Date: 09-Aug-2018
Our Ref: 2018/92308

**TOWN AND COUNTRY PLANNING ACT 1990
TOWN AND COUNTRY PLANNING (GENERAL PERMITTED DEVELOPMENT) (ENGLAND)
ORDER 2015 – SCHEDULE 2, PART 1, CLASS A.1 (g)
AT: 60, Holly Road, Thornton Lodge, Huddersfield, HD1 3SE
Prior notification for single storey rear extension**

The proposal is for erection of single storey rear extension. The extension projects 3.6m beyond the rear wall of the original dwellinghouse. The maximum height of the extension is 4m, the height of the eaves of the extension is 2.65m

BLOCK/SITE PLAN
 AREA 36m x 36m
 SCALE 1:200 on A4
 CENTRE COORDINATES: 413398, 415666

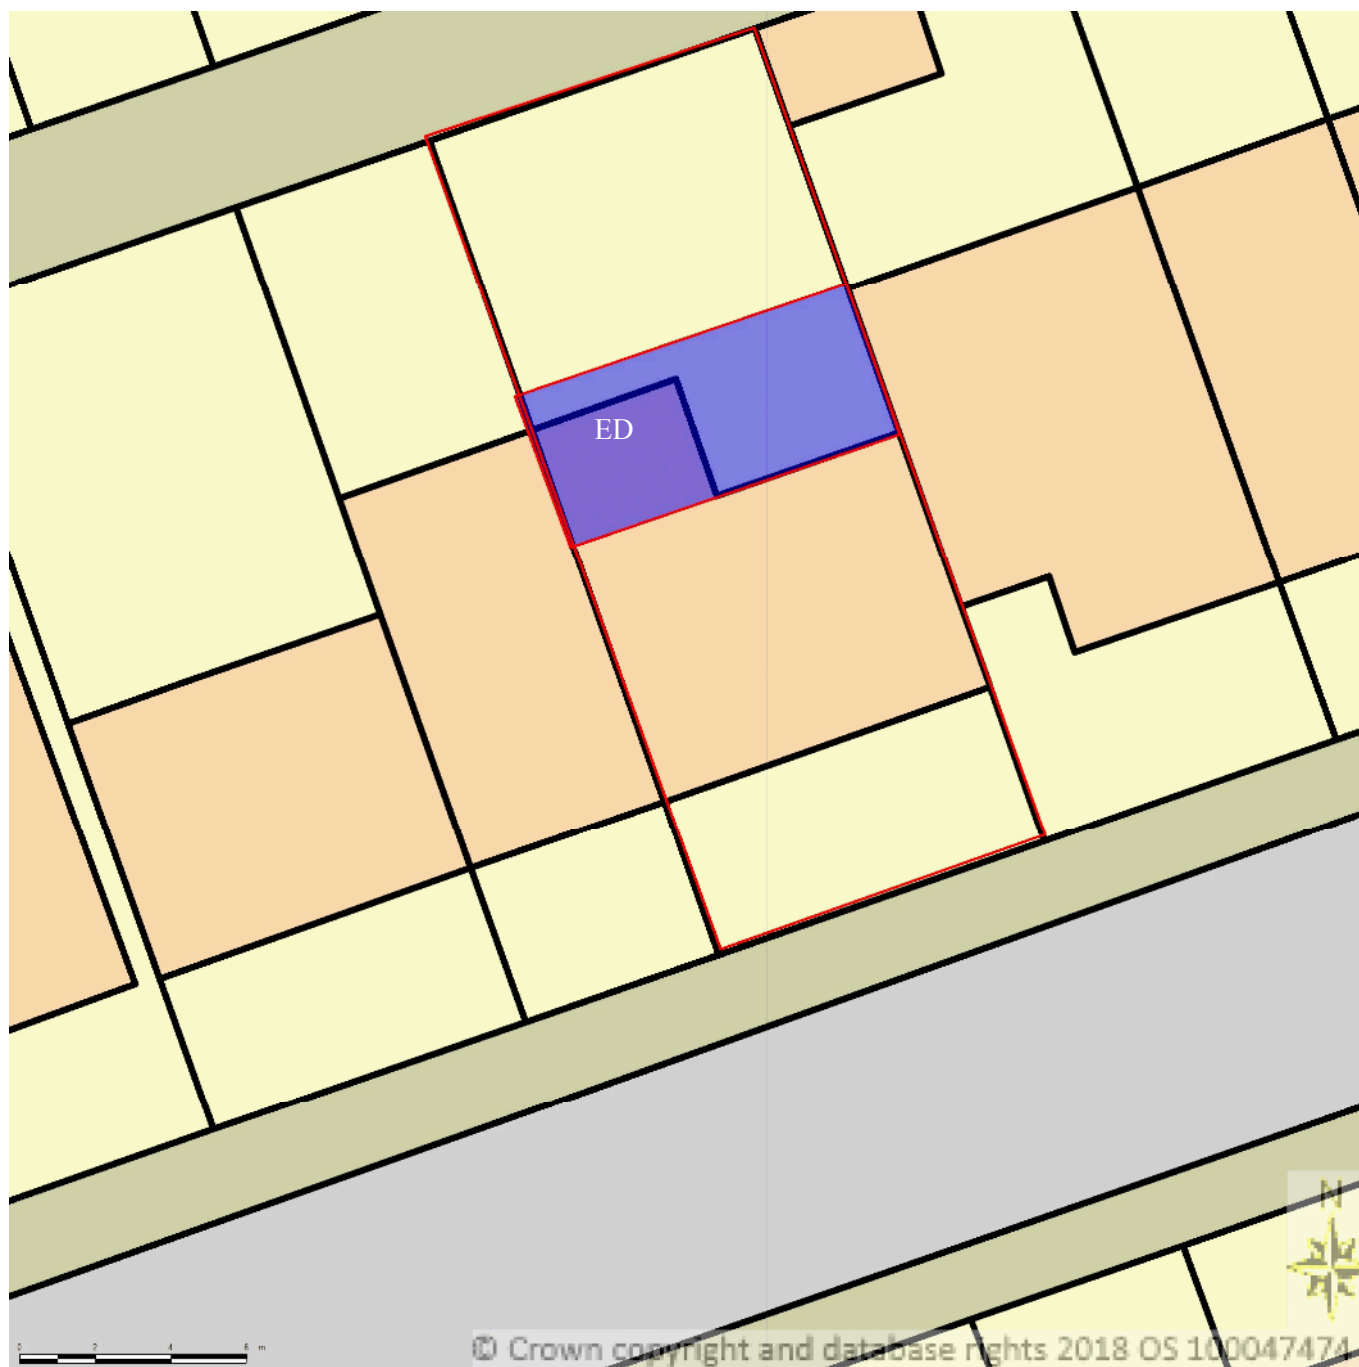
This proposal does not qualify for the criteria of permitted development under Class A, Part 1 of Schedule 2 of the Town and Country Planning (General Permitted Development)(England) Order 2015 (as amended) as proposed extension extends beyond the wall forming an original side elevation of the original dwellinghouse and is greater than half the width of the original dwelling and is adjoining a previous two storey enlargement to the original dwelling. This would exceed the limitations set out in sub section (j)(iii) and ja of Part 1 Class A.
